**Canal &
River Trust**

Your Ref EN010088

Application by EDF Energy (Thermal Generation) Limited for an Order Granting Development Consent for the West Burton C power station

Response to ExA Request for Further Information from the Applicant and the Canal and River Trust - Rule 17

PROJECT	WEST BURTON C
TITLE	OUTLINE STORM WATER DRAINAGE ARRANGEMENT
SCALE	1:200
DATE	11/01/2012
DESIGNED BY	SW
CHECKED BY	CMW
DATE	November 17
PROJECT NO.	70026636-REP-0006-D4
REV	P01

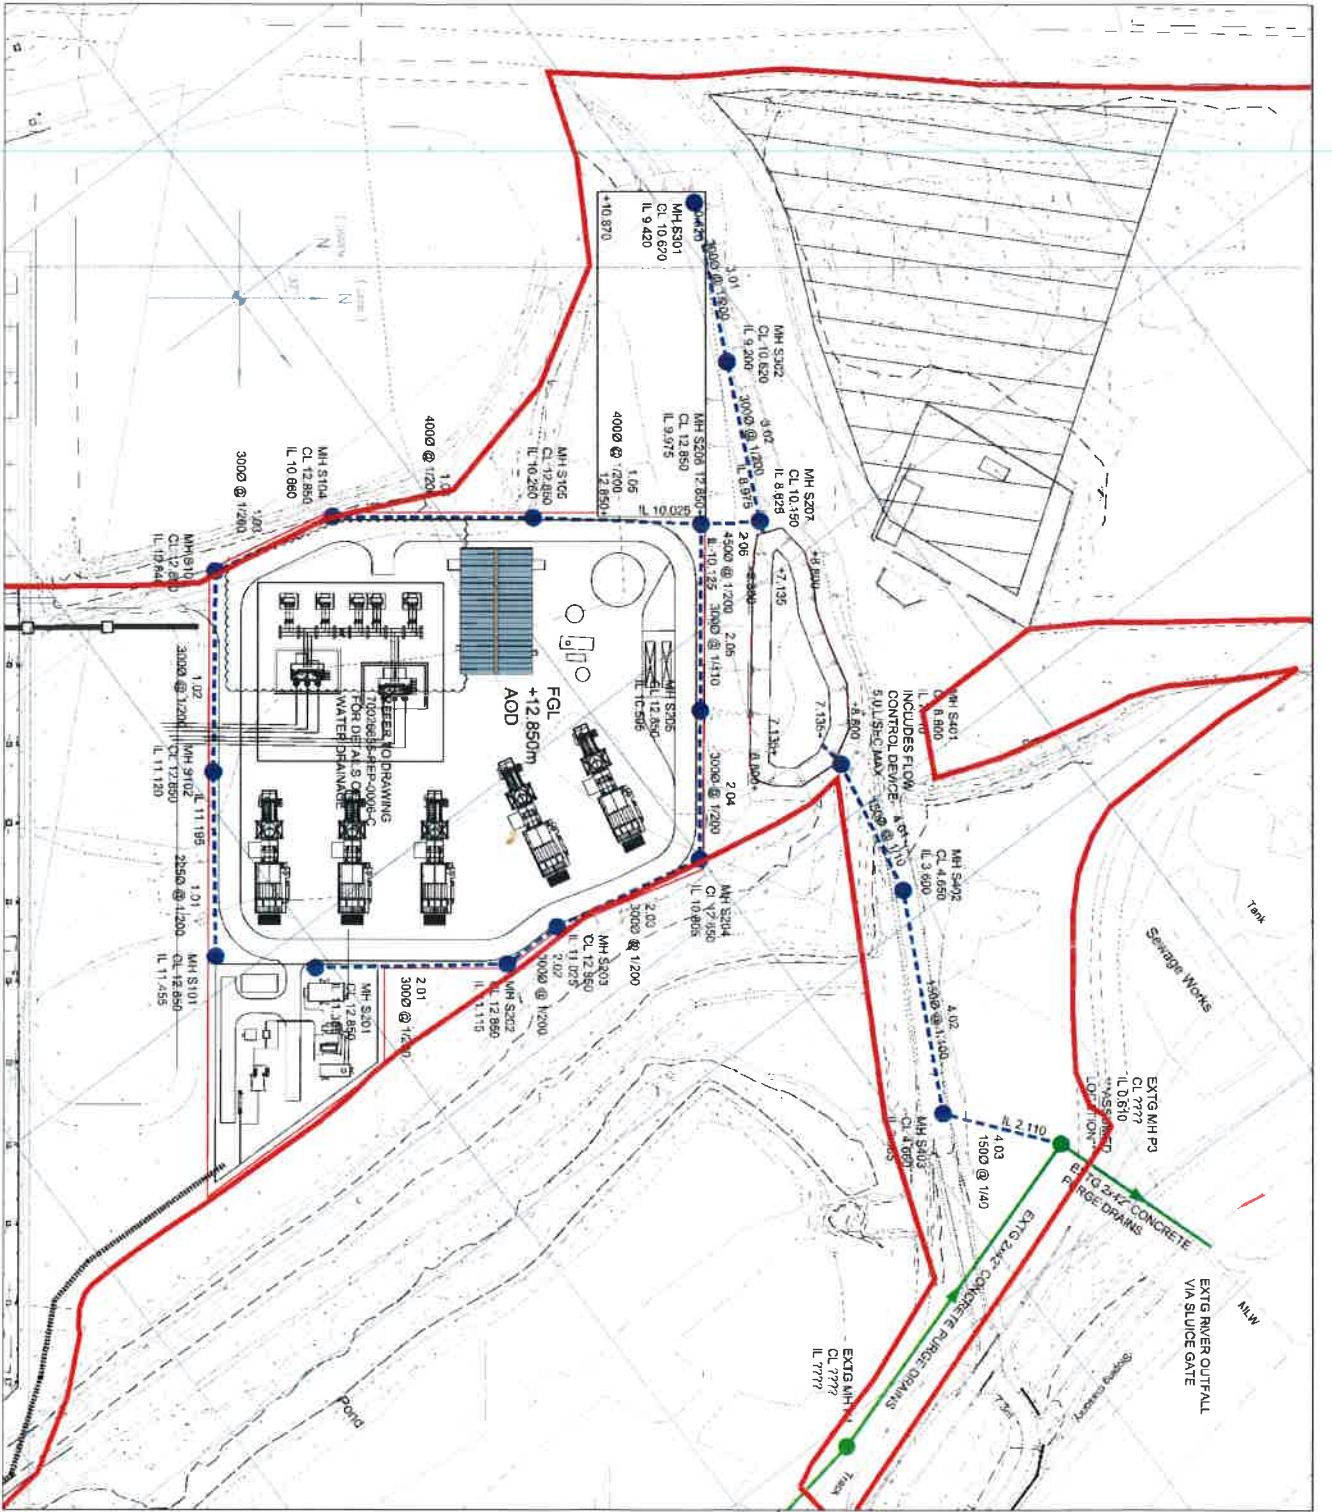
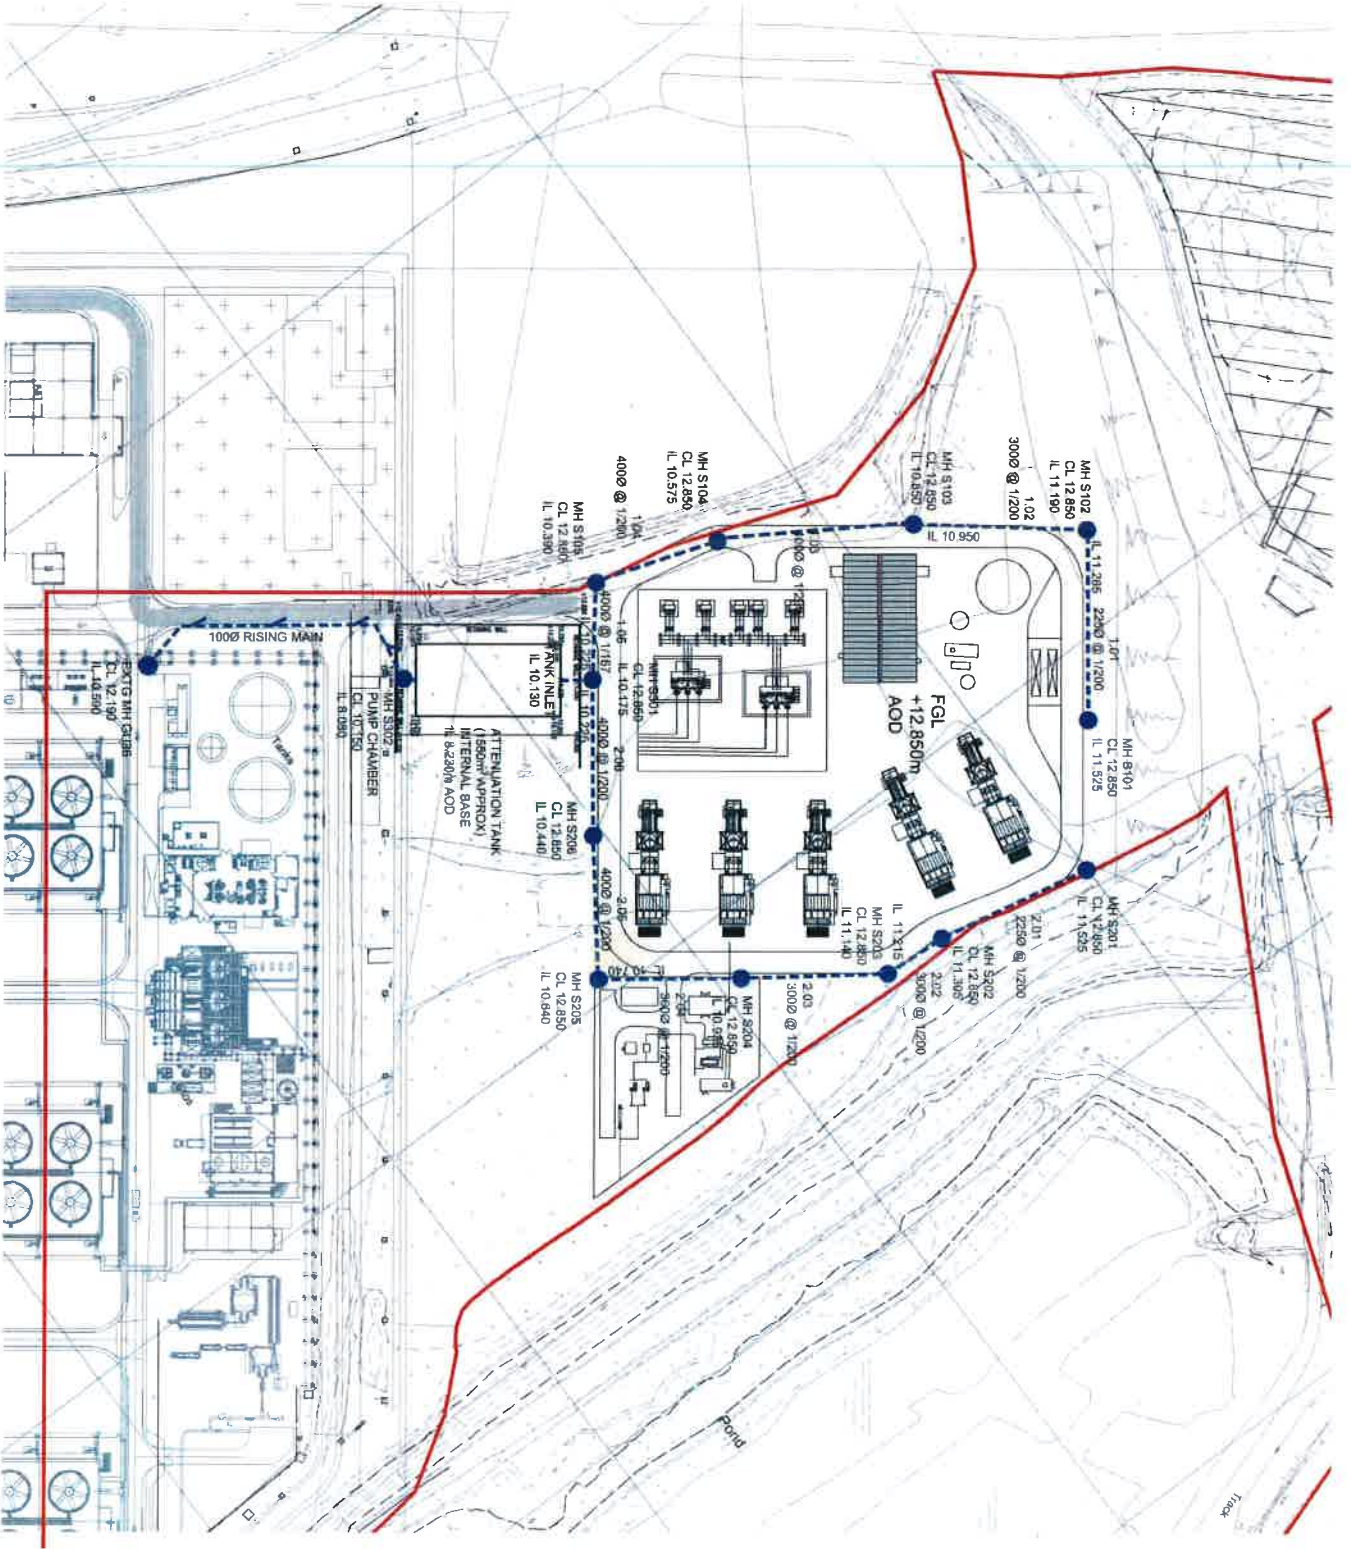
- The position of Connection Option A has now been provided, which is confirmed as being (at closest) approximately 45m metres from the River Trent.
- The detailed arrangement for Connection Option B provided in strategy document (A00-142) was confirmed as also being representative of Option A, including use of a 150mm (6") diameter pipe.

- In terms of construction methodology (whilst not finalised), it has been indicated that the works will be open cut trench work, performed by a JCB (or equivalent) and that there will be no requirement for piling associated with these works.

- the design of the proposed drainage arrangements in Work No. 5, specifically the location and design of the proposed connection;
- a detailed construction method statement and associated risk assessment for works relating to the proposed surface water drainage in the vicinity of the River Trent, including construction traffic management and details of construction and use of any temporary access roads.

Following discussion with the applicant, CRT can confirm that a new or amended requirement 9 could address its concerns in respect of this proposal and any potential impact from construction works on the River Trent. The following proposed wording has been agreed with the applicant in respect of Requirement 9 to address this matter:

9.—(1) In relation to Work No. 1, Work No. 2, Work No. 4 and Work No.5, no development must commence until, where relevant for that Work, details of the temporary surface water drainage system, including means of pollution control, have been submitted to and, after consultation with the Environment Agency, Lead Local Flood Authority, relevant internal drainage board and Canal & River Trust in relation to Work No. 5 only, been submitted to and approved in writing by the relevant planning authority.

(2) Details of the permanent surface water drainage system, including a programme for its implementation and maintenance, must be submitted to and, after consultation with the Lead Local Flood Authority, Environment Agency, relevant internal drainage board and Canal & River Trust in relation to Work No. 5 only, be submitted to and approved by the relevant planning authority prior to the start of construction of any part of that system.

(3) The details submitted and approved pursuant to paragraphs (1) and (2) of this requirement in relation to Work No. 5 must include a detailed construction method statement for the proposed works, including temporary access arrangements and construction vehicle routes to facilitate the drainage connection.

Figure 2. HGV Designated Route Plan (Proposed Development Construction)

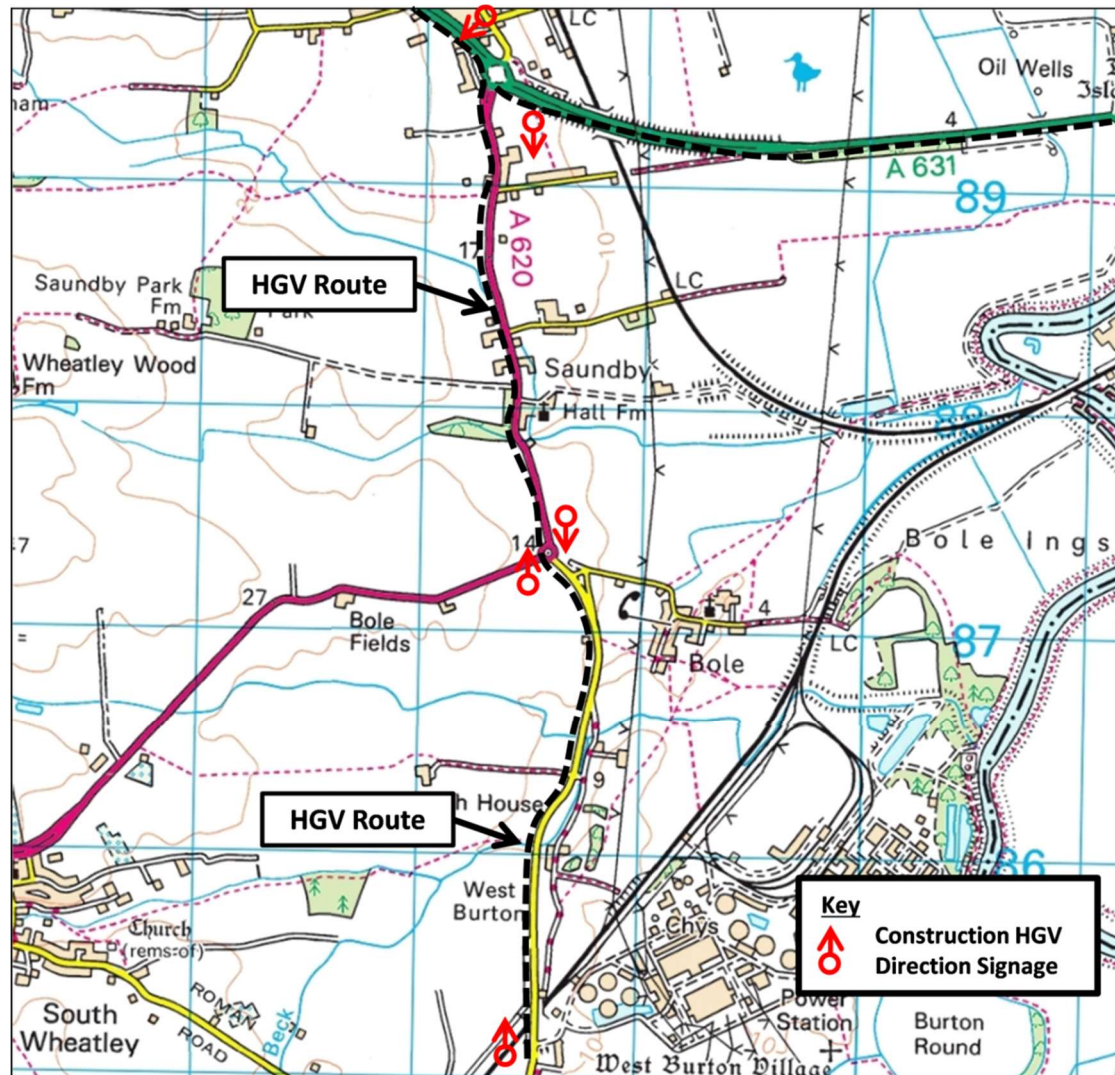
- Construction vehicles will not use River Road alongside the River Trent. We note that confirmation of this matter has also been sought by the ExA in Question 3 of the recent request for further information (5 February)

In addition, the applicant has proposed that the following text will be included in the next version of the Framework Construction Traffic Management Plan (document 7.6):

2.1.3 In order that it is not affected by construction traffic, construction access within the West Burton Power Station site will exclude the use of River Road.
